# Together Against Sizewell C

**TOGETHER AGAINST SIZEWELL C (TASC) IP NO. 20026424**

**COMMENTS RELATING TO THE APPLICANTS D5 SUBMISSION**

**DOCUMENT 9.57 ACOUSTIC FISH DETERRENT REPORT [REP5-123]**

Figure 3.1: Intake Locations (blue lines; 2 from 3 locations on each tunnel to be selected)

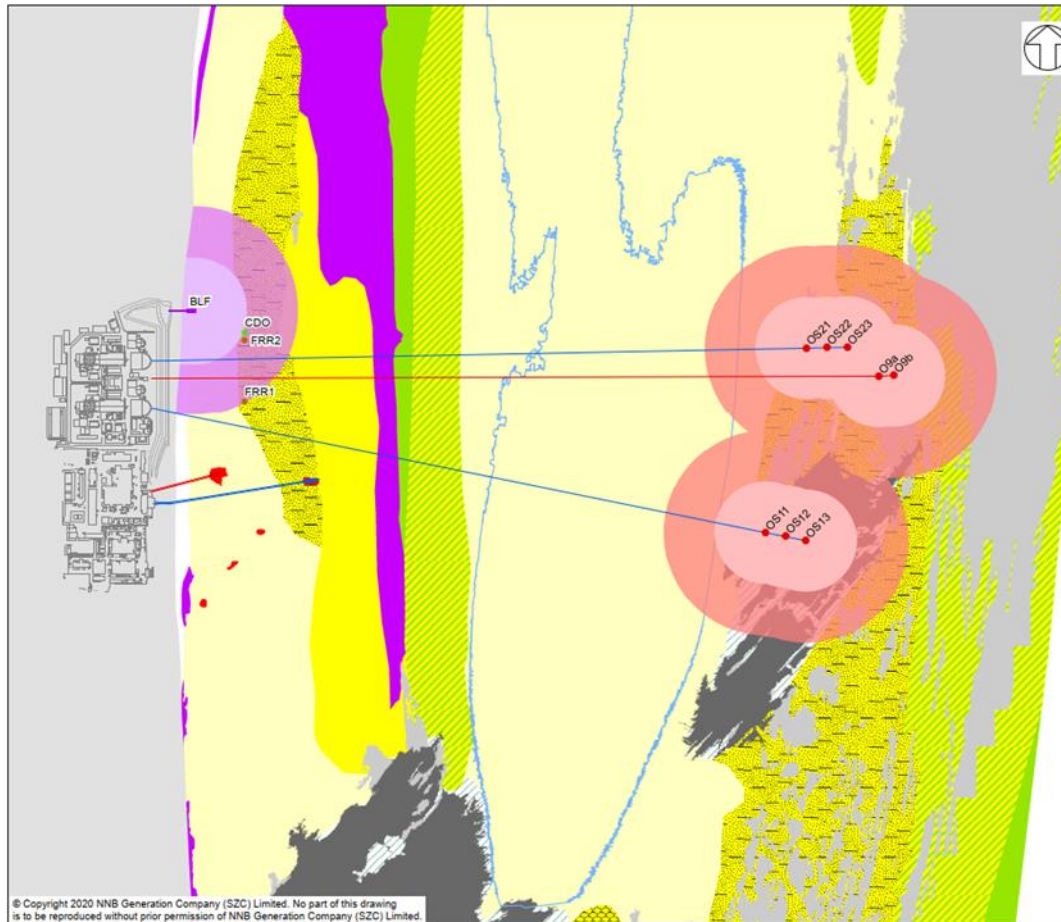
4. If an intake 3.5 km offshore cannot be maintained to reduce biofouling and install AFD, then consideration should be given to either redesigning it or moving it further inshore where it can be maintained. There appears to have been no consideration of

other intake designs. The Applicant seems to be saying that the intake has to be 3.5 km offshore just like the Hinkley intake: why?
